Date 30 September 2021
Our Ref 21/01476/CLE

**Town and Country Planning Act 1990 (As Amended)
Copper Beech, Kingsdown Road, Epsom
Refurbishment and widening of existing crossovers including dropped kerb (Application
for a certificate of lawful development).**

# Site Plan

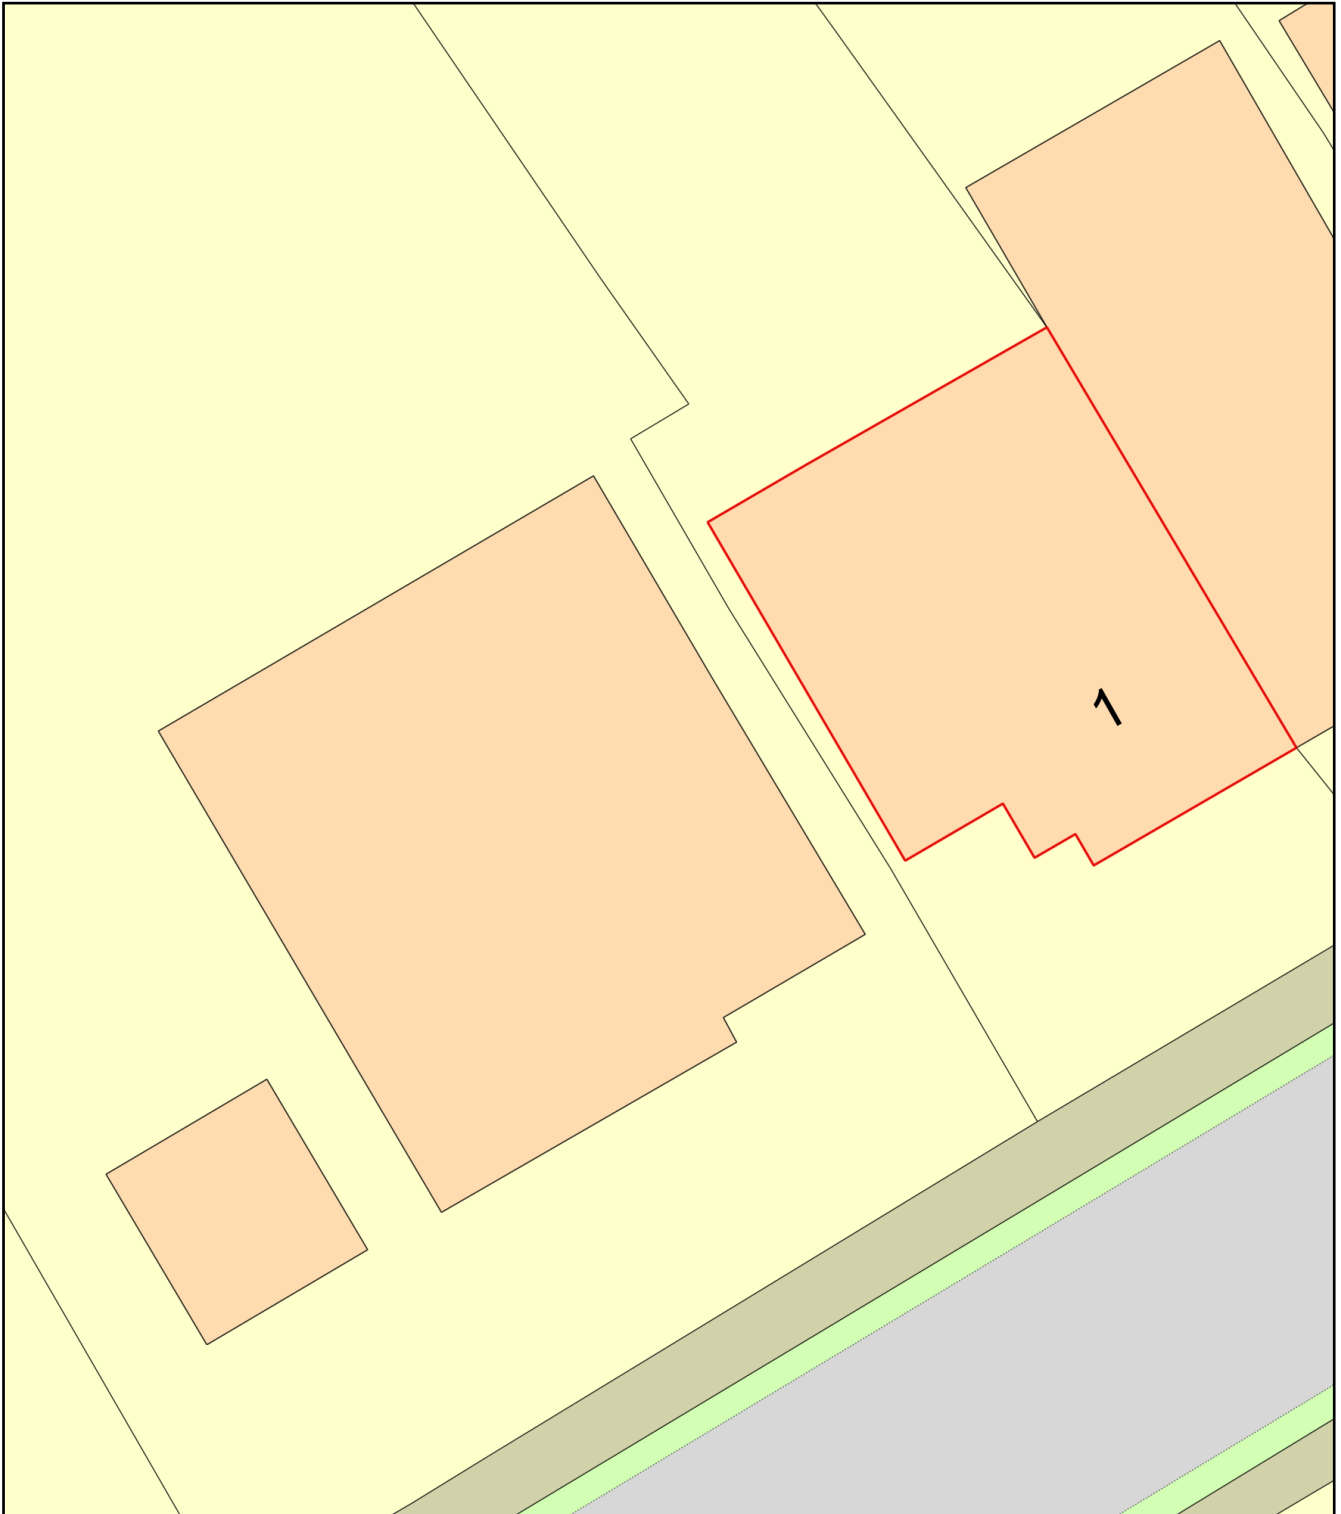
o Site Location Plan at scale 1:1250 with the site boundary lines highlighted in red around the application site.
o Existing and Proposed Block Plan at scale 1:200 or 1:500, the Proposed Block Plan must demonstrate the location of the drop kerb and the dimension of the drop kerb and crossover. Please send an email requesting the withdrawal of the current Certificate application.
